Mr. Robert Greenlaw, P.L.S.
Back Bay Boundary, Inc.
65 Newbury Street
Portland, ME 04101

Subject: 101 Rowe Avenue
(ID # 2003-0185) (CBL# 261B022)

Thank you for your application for a single family at 101 Rowe Avenue. Upon review of the plan, it appears that this design would constitute a subdivision.

DRAWN BY: DMD
 CHECKED BY: CAS
 SCALE: 1" = 40'
 DATE: 4/23/2003
 JOB NUMBER: 200338
 SHEET: 2 OF 2

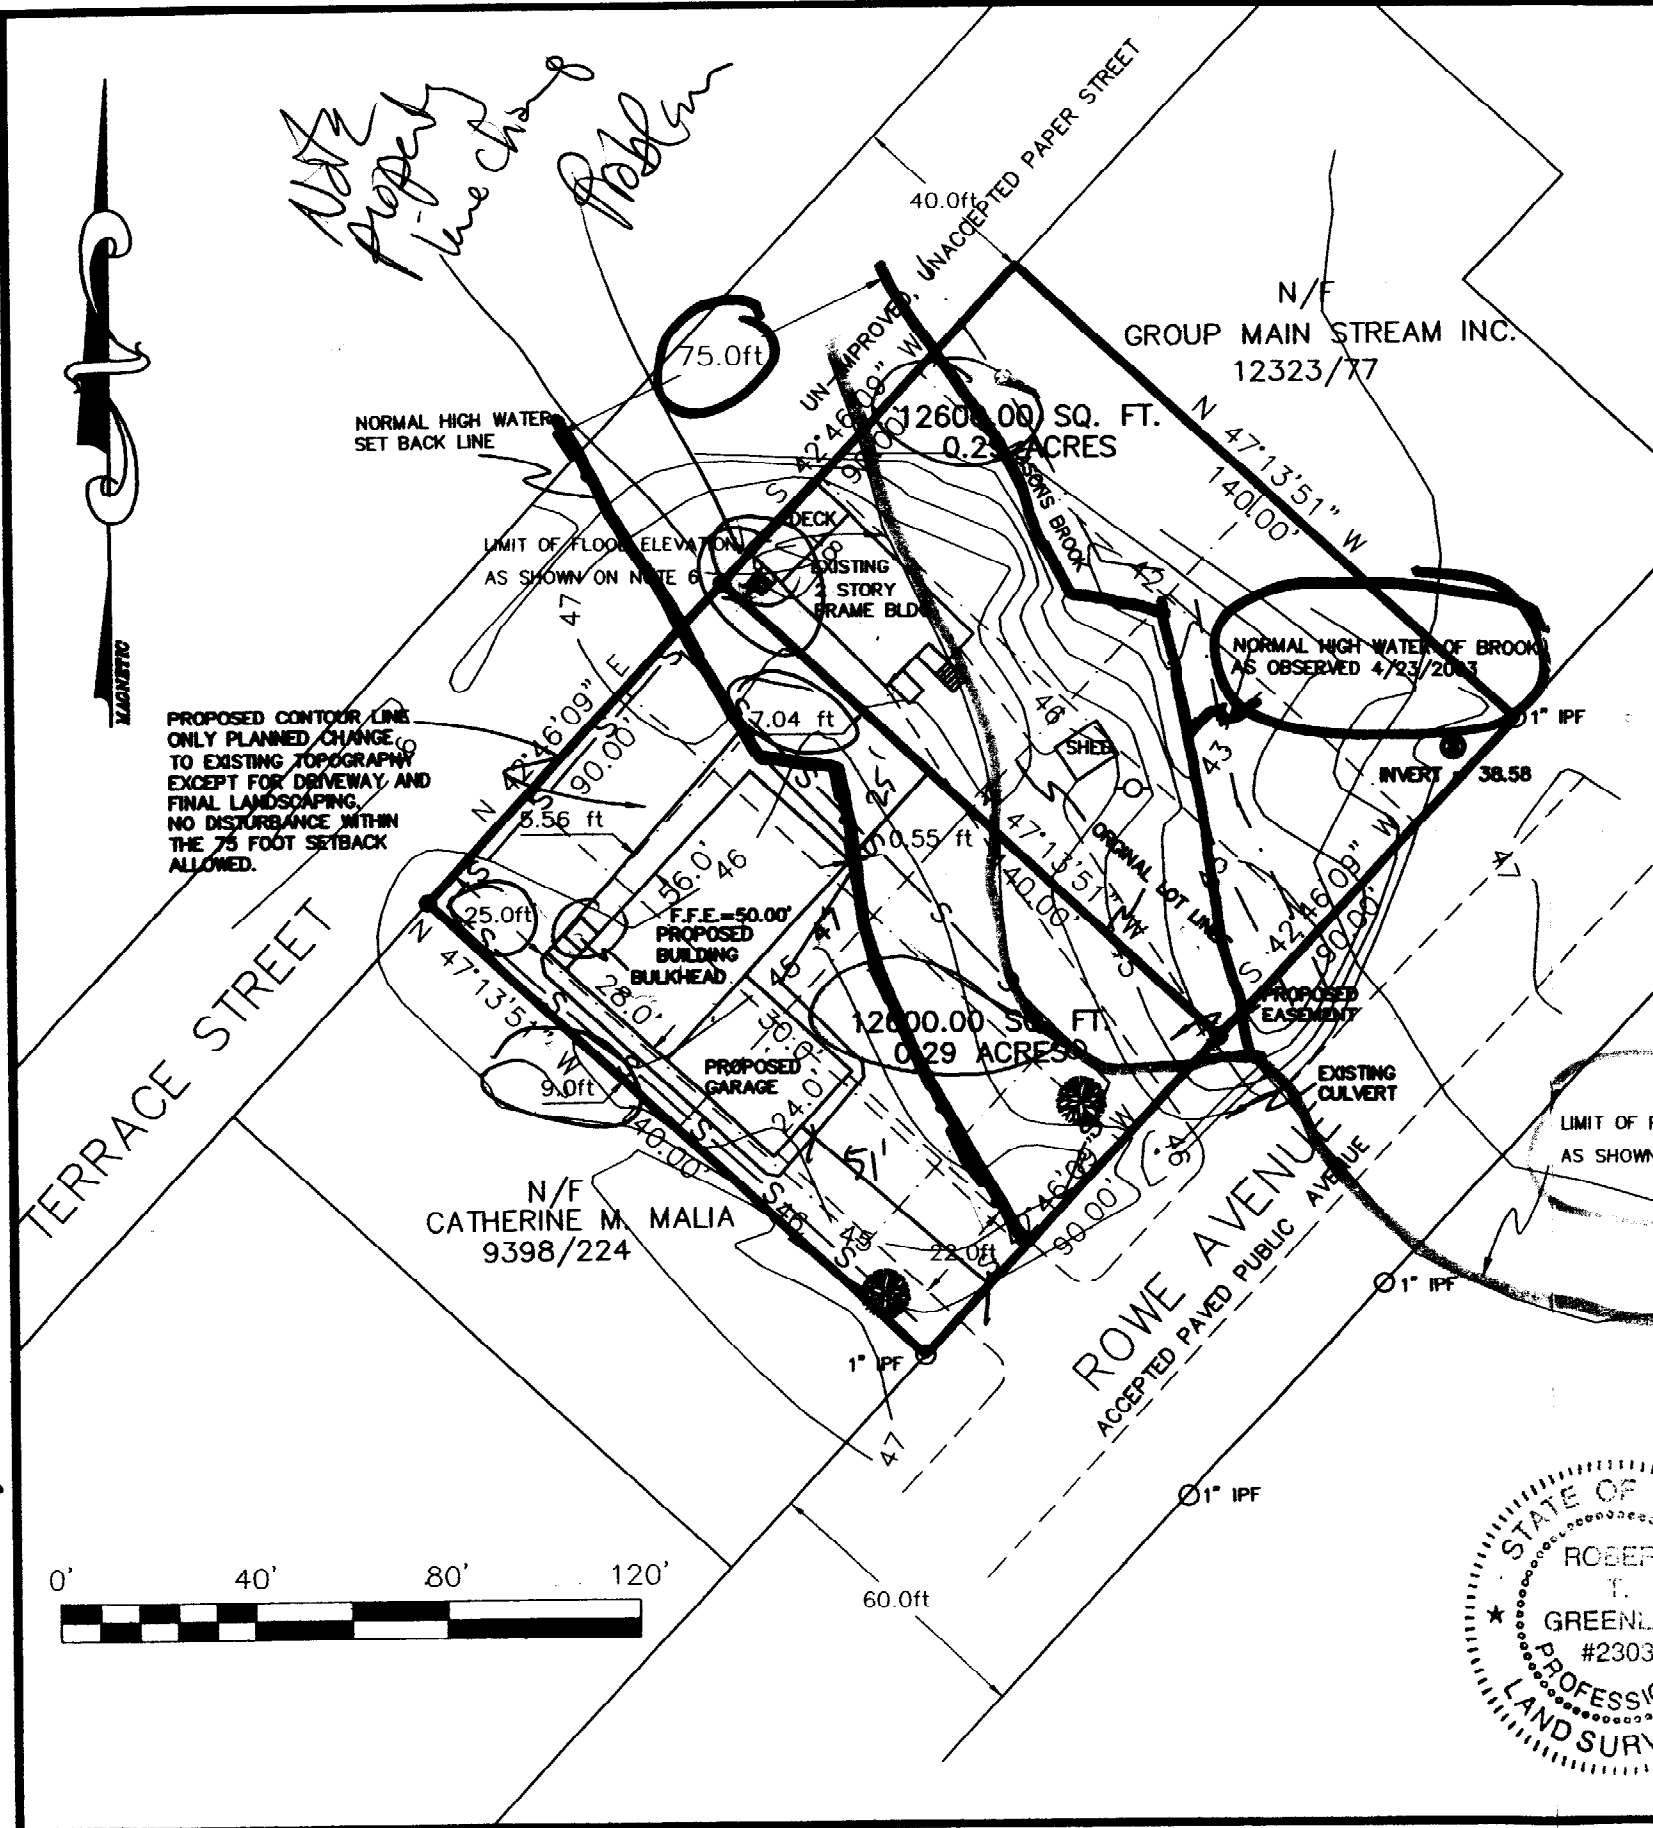
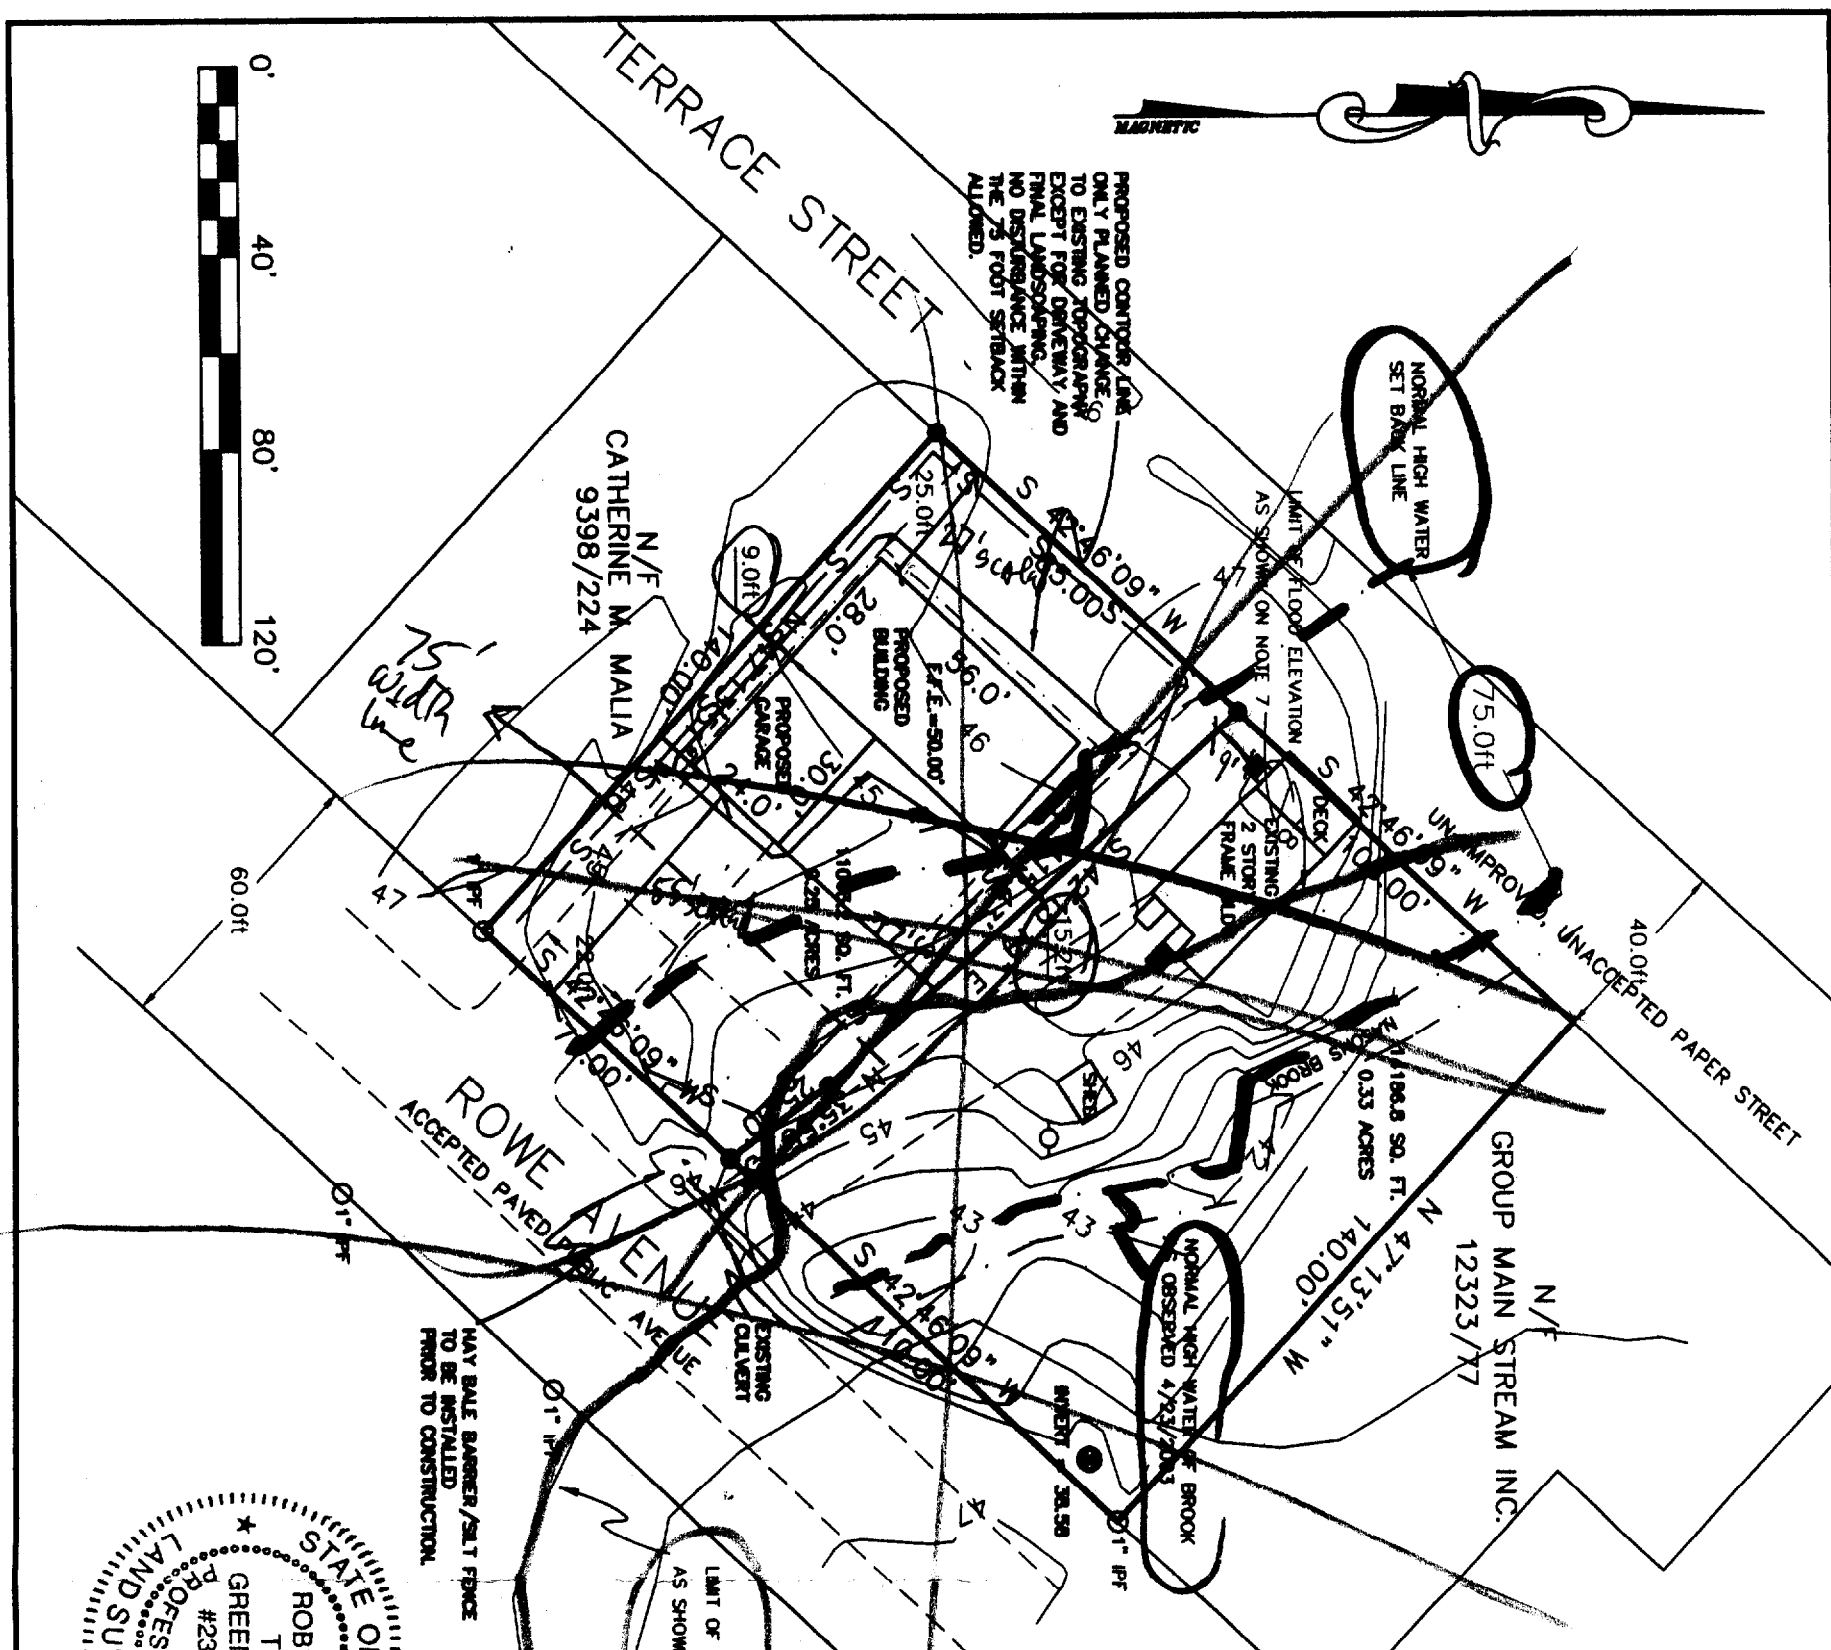
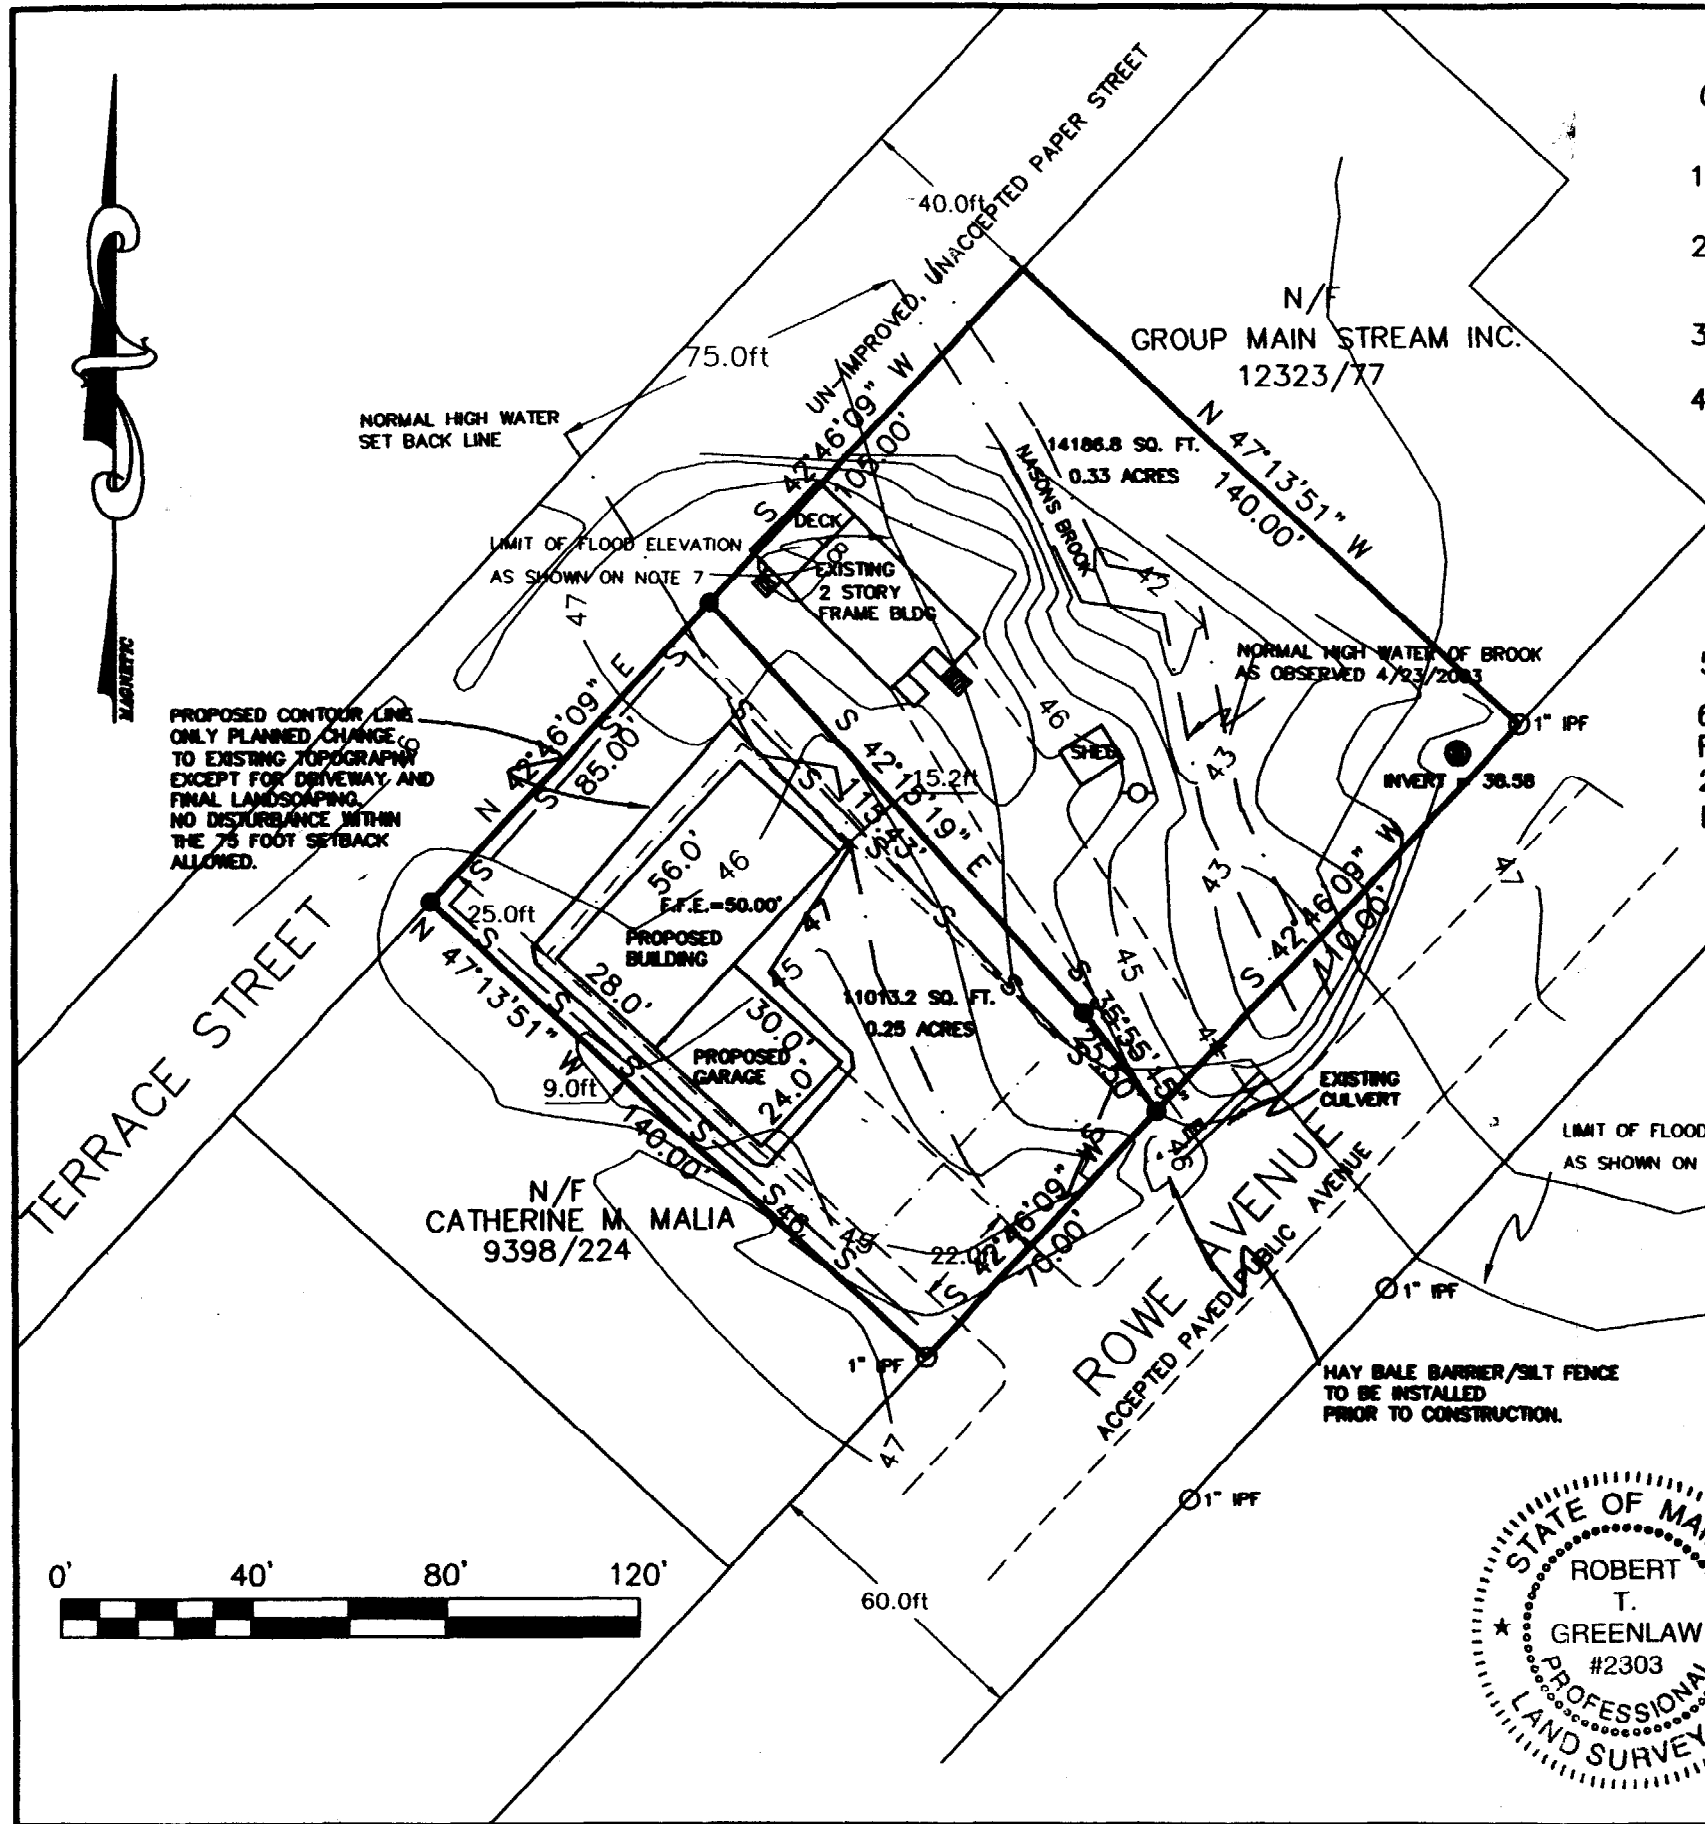
1. Please show all proposed topography (it appears incomplete in the front of the building).
2. The site appears to be within a stream protection zone. Please add the limits of the zone to the site plan.
3. Please add erosion control measures to the site plan.
4. One of the boundary line distances on the adjacent property is incorrect (either 105.00' or 110.00').
5. Please add the required street trees along the street frontage of the property.
